25th November 2020

RE: Planning Application - AW/251/20/OUT – 14 Princess Avenue – Aldwick

Proposed Site Layout Plan at 1:100 scale

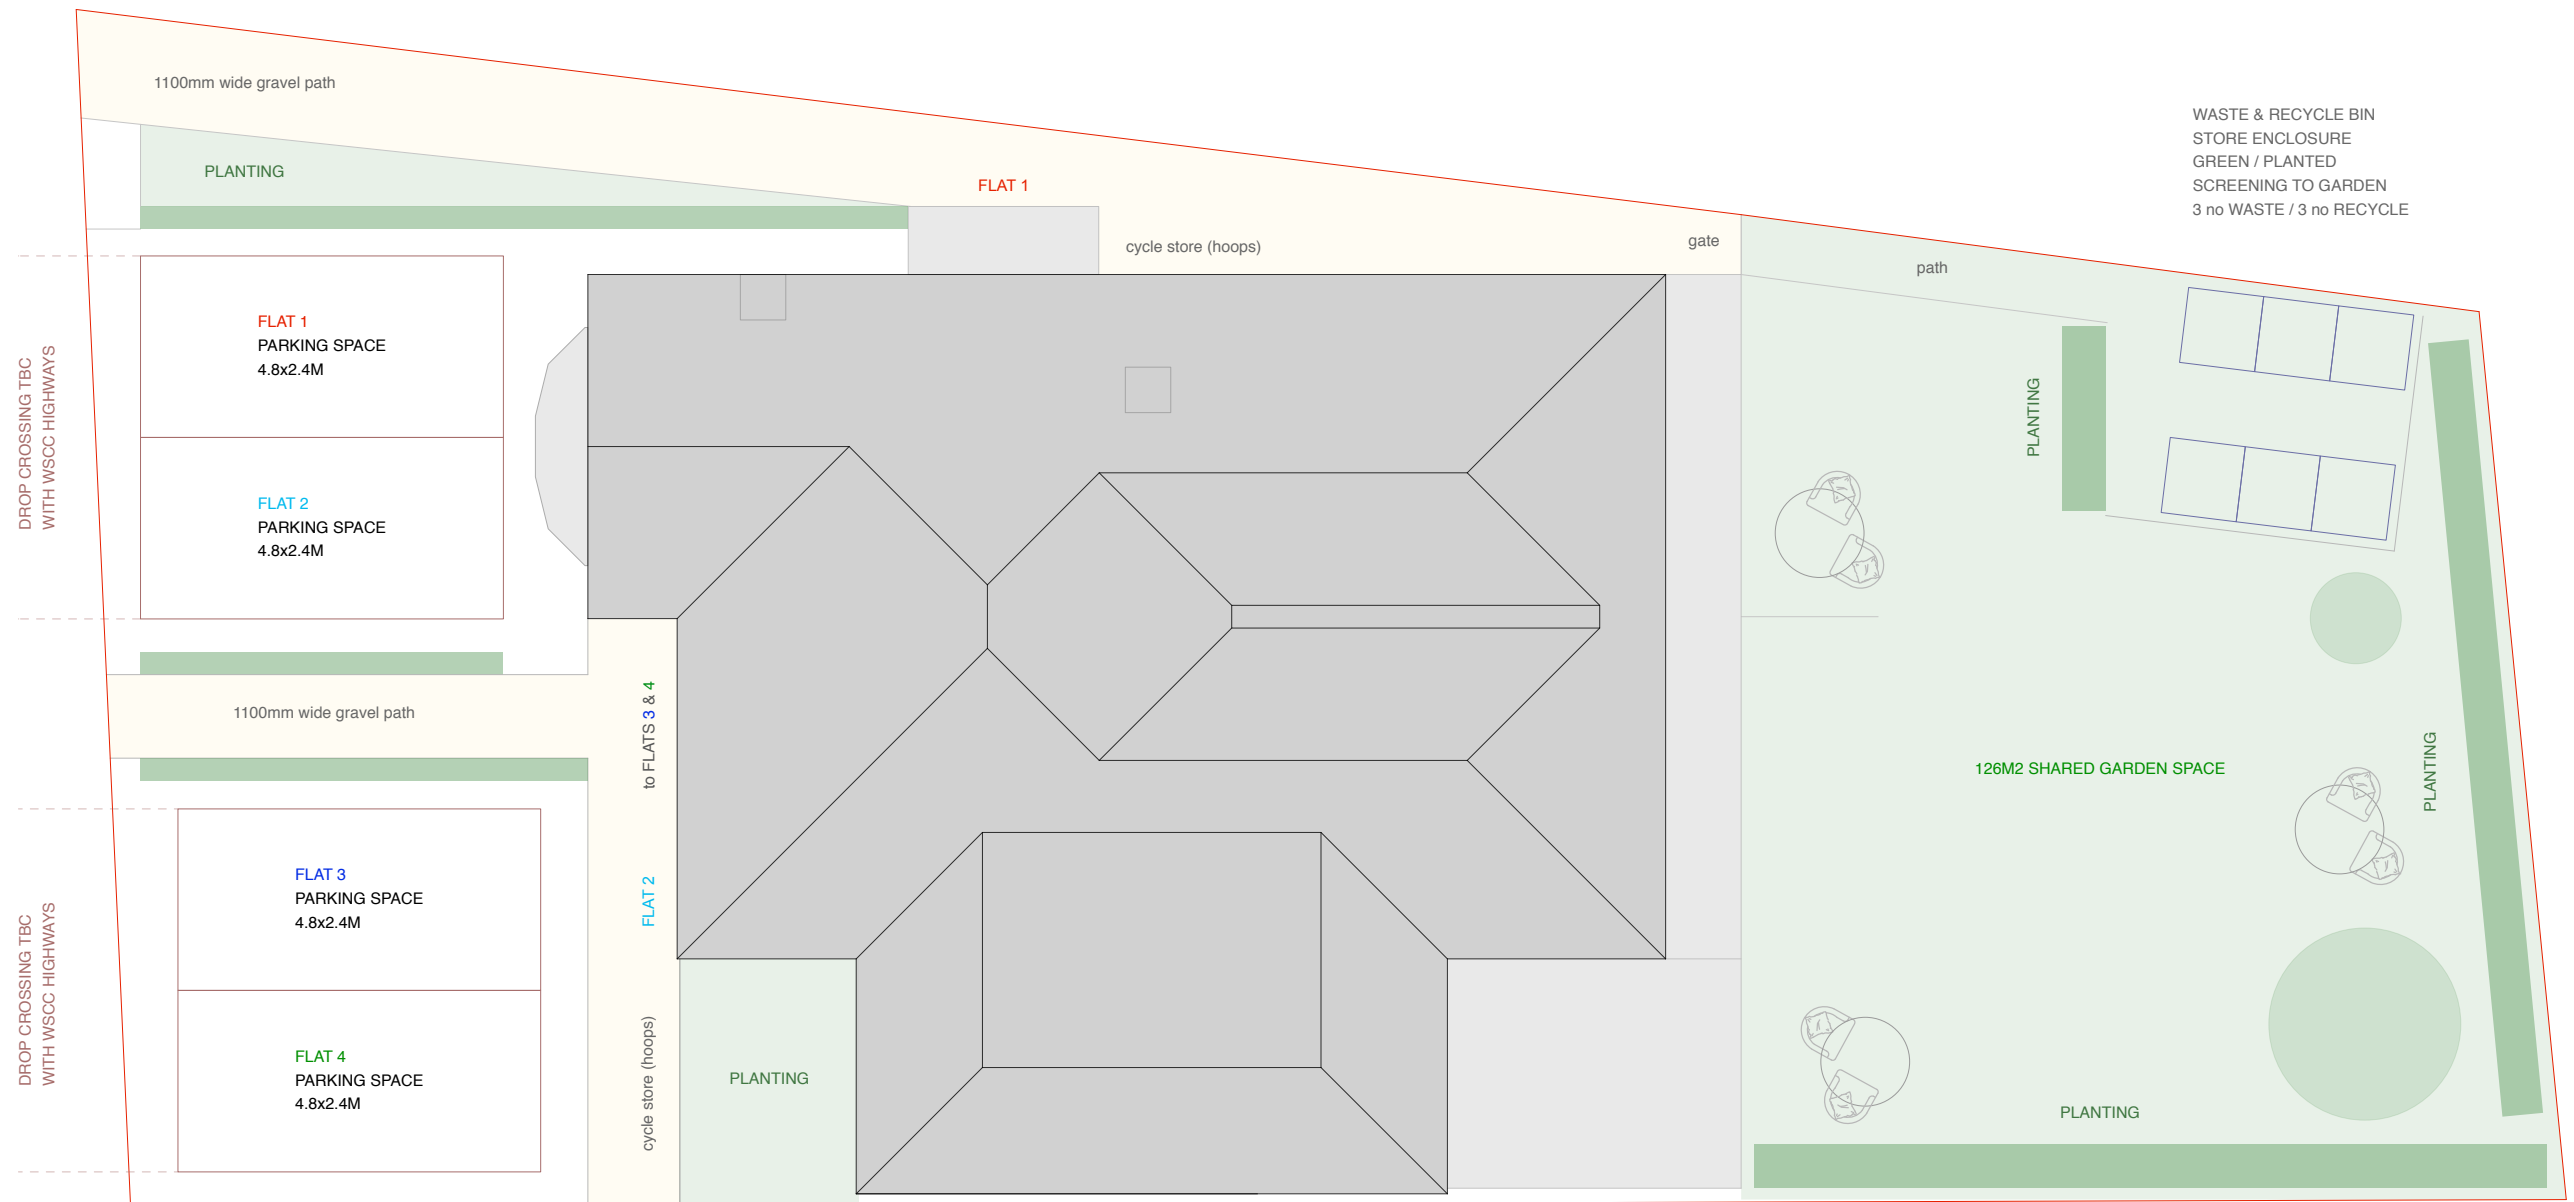
In support of their application the Applicant has submitted a Drawing No 8 - Proposed Site Layout Plan - Waste and Recycle Store - Elevations.

The applicant proposes to grub out the trees, (known habitat of small nesting birds), in the rear garden and erect waste bin stores. The stores will be open to the air in summer and winter and their rotting waste will release noxious odours into the air counter to - Policy QE SP1 of Arun Adopted Local Plan 2018 – *Quality of the environment*.

Every week the occupants of the four flats will be required to manoeuvre four black Waste Bins from the bin store in the rear garden to the road frontage of 14 Princess Avenue and back. Each single bin journey will be twenty-eight metres from bin store to road. The round trip for each bin will therefore be some fifty-six metres or 280 metres for all five bins.

There are trees in both front and rear gardens at 14 Princess Avenue. It is clear from Drawings 8 - Proposed Site Layout Plan from both front and rear gardens that all trees and grass are to be removed in order to ‘Tarmac over’ the whole of the front garden for car parking which is counter to the character and appearance of the area. In the rear garden the trees next to the north wall of the garden will need to be completely removed in order to build the Waste Bin Store and the Cycle Store as shown in Drawing No 8 – Site Plan.

Proposed Ground Floor Plan at 1:100 scale

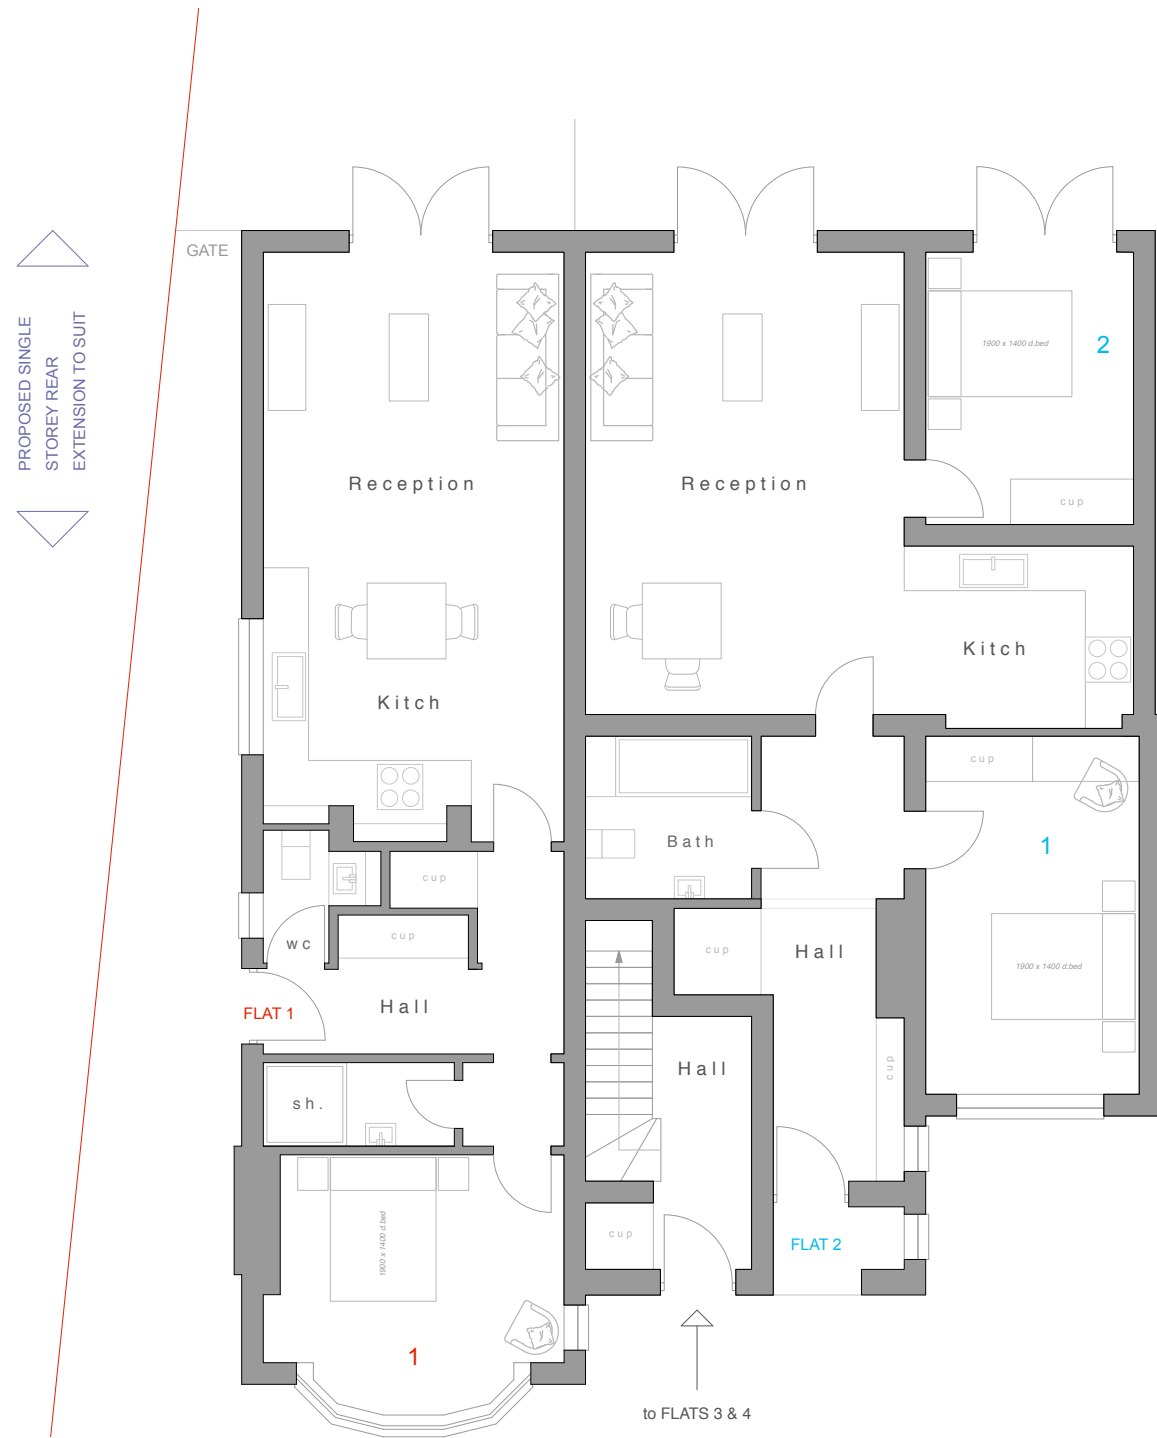
Examination of Drawings Nos. 2 and 4 – Proposed Ground Floor Plan and rear elevation South East shows that patio doors to the garden are proposed for the reception rooms and of Ground Floor Flats 1 & 2 and for the rear bedroom of Flat 2. This means there will inevitably be movement and noise from the back of the proposed development. Currently there is no such activity or noise and neighbouring properties enjoy quiet at the rear of their properties with neither sound nor lighting at night. Our experience has been, with Sandringham Wessex Avenue where similar

Proposed Rear Elevation at 1:100 scale
SOUTH EAST

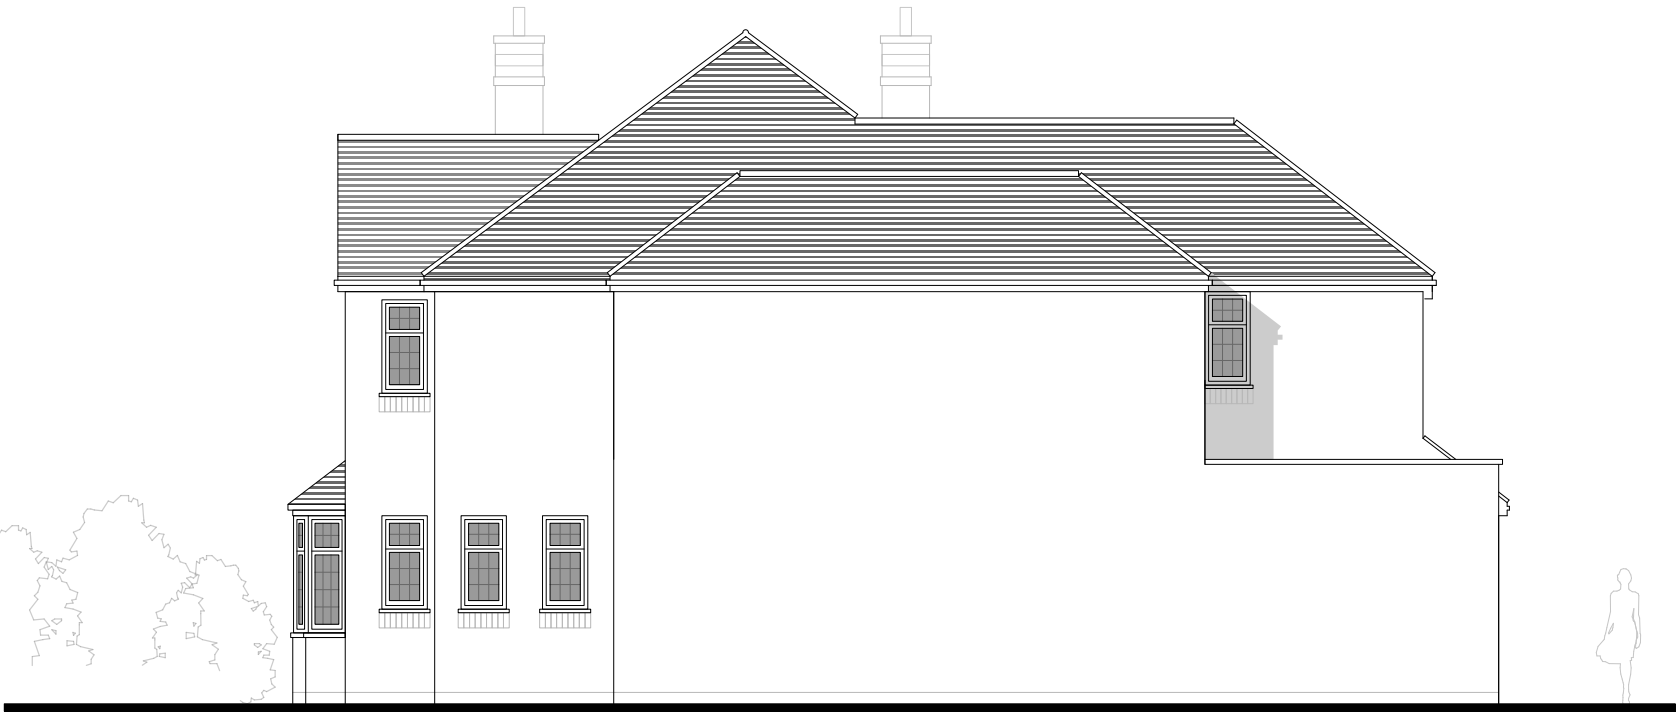
The living room windows of the proposed First Floor Flats give occupants a permanent and penetrating view into our bedrooms, living rooms and garden. They have no other living room window on the outside world. Their view, by unfortunate design, is significantly cast upon our private rooms and garden.

About half of the rear face of the proposed design is window glass. When fully occupied the house will emit, at the rear, at night, a vastly increased volume of light, than the existing property. Even more lighting will be required to give safe night-time access to the doors at the rear of the property and to the waste and recycle bins. There will also doubtless be a requirement for intruder deterrent security lighting.
